**HINCKLEY NATIONAL  
RAIL FREIGHT INTERCHANGE**

**Sapcote Technical Note [Appendix 2 (D) – Enhanced  
Scheme Stage 1 RSA and Designers Response Report]**

# PROPOSED TRAFFIC CALMING AND ZEBRA CROSSING

## STAGE 1 ROAD SAFETY AUDIT

**SAPCOTE ENHANCED
SCHEME
VISIBILITY TO
PEDESTRIAN CROSSINGS**

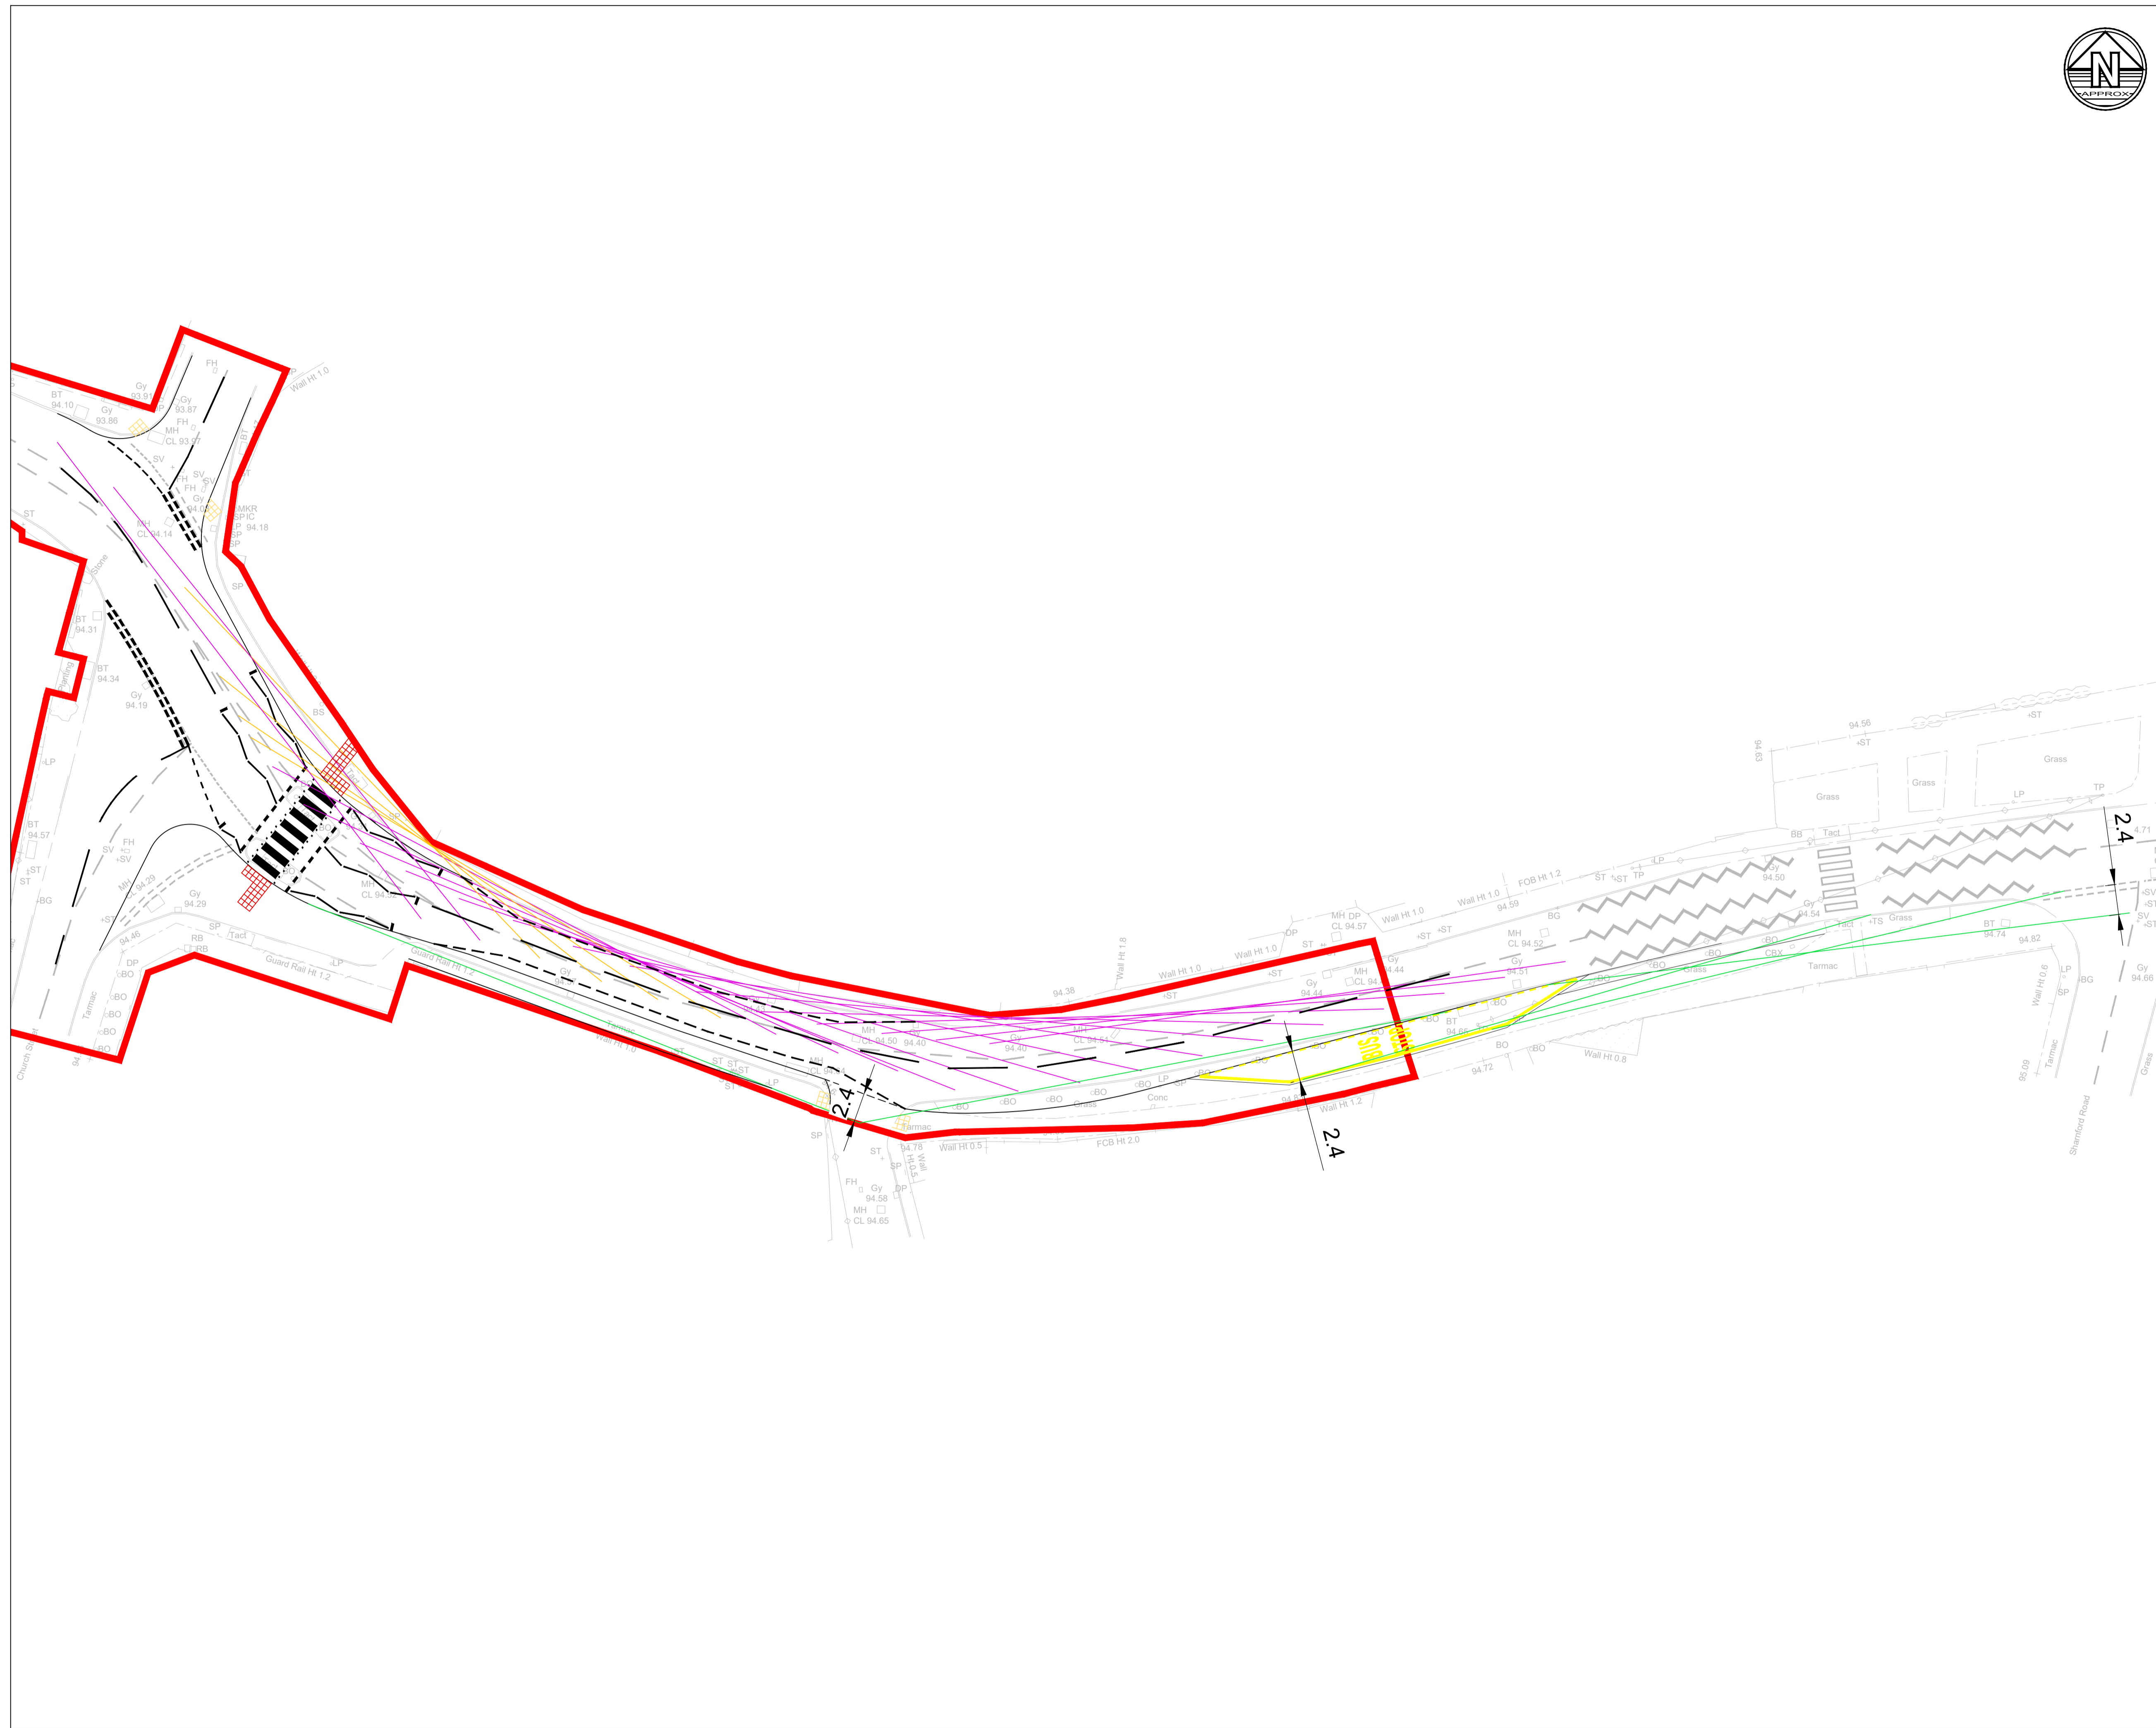
Location: B4669 Hinckley Road - proposed pedestrian crossing to the west of the junction with Stanton Road.

Summary: Restricted visibility risks vehicle to pedestrian collisions.

Although visibility was available during the site visit, historical images show parking along the northern kerb outside of the Sapcote Club and adjacent properties that will limit visibility for and of pedestrians looking to cross north to south at the proposed pedestrian dropped crossing here. This risks pedestrians entering the carriageway into the path of an eastbound vehicle, resulting in vehicle to pedestrian collisions.

It is recommended that, as part of the detailed design, waiting restrictions are provided to ensure that unobstructed visibility commensurate with approaching vehicle speeds is provided at the crossing.

RSA Ref.	RSA Problem and Recommendation	Design organisation response	Auditor Response	Agreed RSA action
	<p>Location: B4669 Hinckley Road - proposed pedestrian crossing to the west of the junction with Stanton Road.</p> <p>Summary: Restricted visibility risks vehicle to pedestrian collisions.</p> <p>Although visibility was available during the site visit, historical images show parking along the northern kerb outside of the Sapcote Club and adjacent properties that will limit visibility for and of pedestrians looking to cross north to south at the proposed pedestrian dropped crossing here. This risks pedestrians entering the carriageway into the path of an eastbound vehicle, resulting in vehicle to pedestrian collisions.</p> <p>Recommendation:            It is recommended that, as part of the detailed design, waiting restrictions are provided to ensure that unobstructed visibility commensurate with approaching vehicle speeds is provided at the crossing.</p>	<p>Agree with RSA recommendation: Yes</p> <p>As part of the detailed design, waiting restrictions will be considered and provided through a TRO if agreed by the Overseeing Organisation and subject to appropriate consultation. A note has been added to the revised drawings.</p>	<p>The Audit Team would consider this response to provide unobstructed visibility splays, as per the recommendation, pending the length of the proposed restrictions.</p>

**Sapcote Enhanced Scheme
Appendix C (part 5)
Vehicle Tracking Sheet 1**

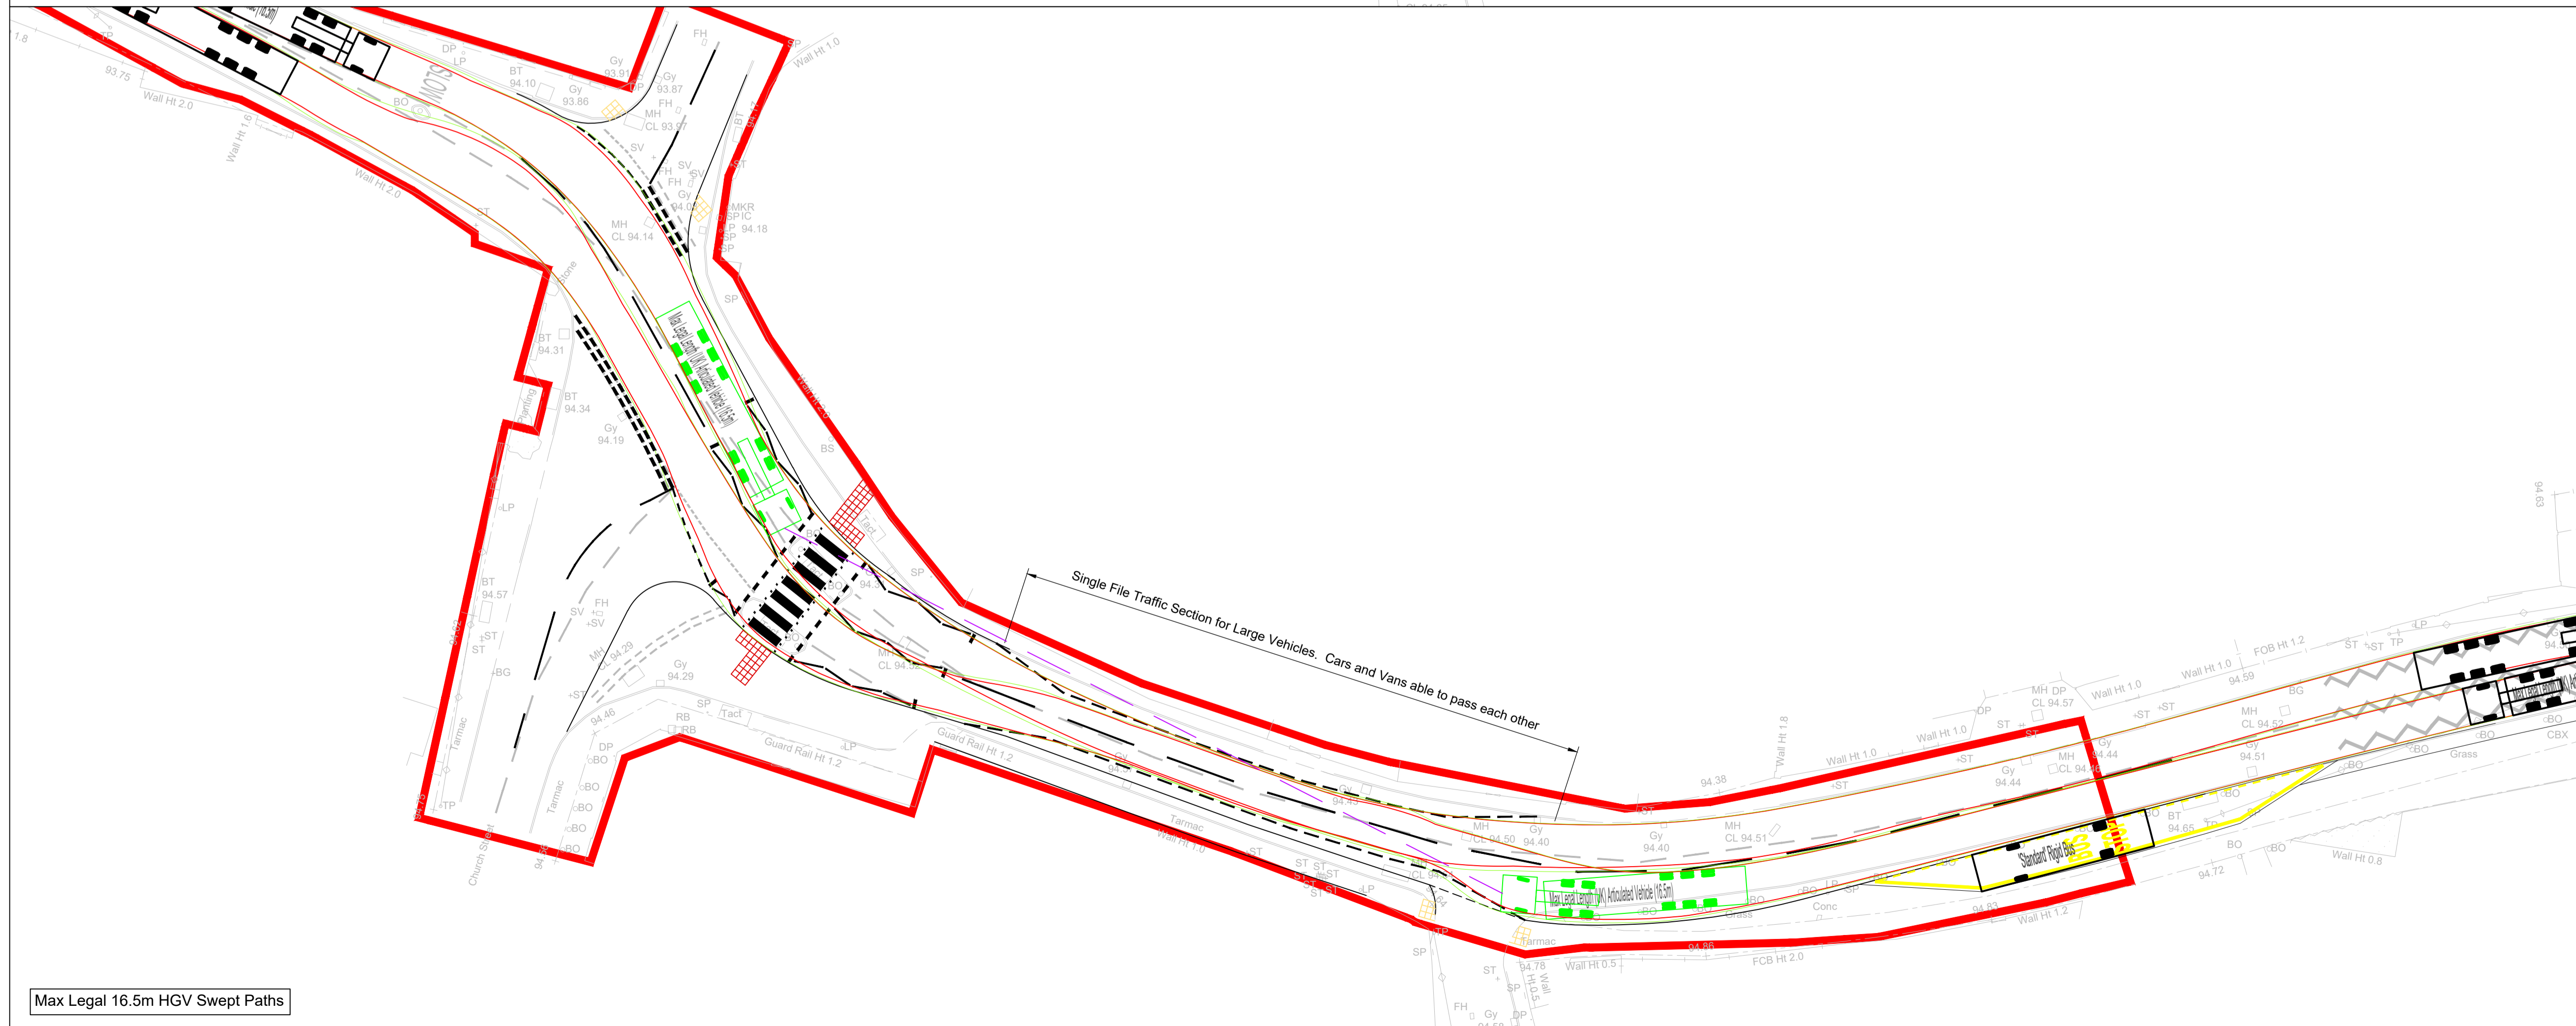
Location: B4669 Hinckley Road – “Oncoming vehicles in middle of the road” section.

Summary: Unfamiliar use of signing / road markings risks offside to offside collisions.

The “Oncoming vehicles in middle of road” signs are generally used where a physical restriction – such as a bridge requires large vehicles to be driven in the centre of the carriageway. The lack of an obvious reason for the warning signs and markings may result in failures for some drivers to slow or give way to large vehicles, resulting in offside to offside collisions.

It is recommended that reference is made to the need for large vehicles specifically to use the centre of the carriageway, for example the use of a vehicle activated sign with large vehicle detection.

<p>Location: B4669 Hinckley Road – “Oncoming vehicles in middle or the road” section.</p> <p>Summary: Unfamiliar use of signing / road markings risks offside to offside collisions.</p> <p>The “Oncoming vehicles in middle of road” signs are generally used where a physical restriction – such as a bridge requires large vehicles to be driven in the centre of the carriageway. The lack of an obvious reason for the warning signs and markings may result in failures for some drivers to slow or give way to large vehicles, resulting in offside to offside collisions.</p> <p>Recommendation: It is recommended that reference is made to the need for large vehicles specifically to use the centre of the carriageway, for example the use of a vehicle activated sign with large vehicle detection.</p>	<p>Agree with RSA recommendation: Yes</p> <p>A location for vehicle activated signage has been shown on the updated general arrangement with the exact details of the form of sign, text and activation to be agreed at detailed design.</p>	<p>Noted – The exact location and design of fixed and vehicle activated signage should be agreed at Detailed Design and reviewed at the Stage 2 RSA.</p>
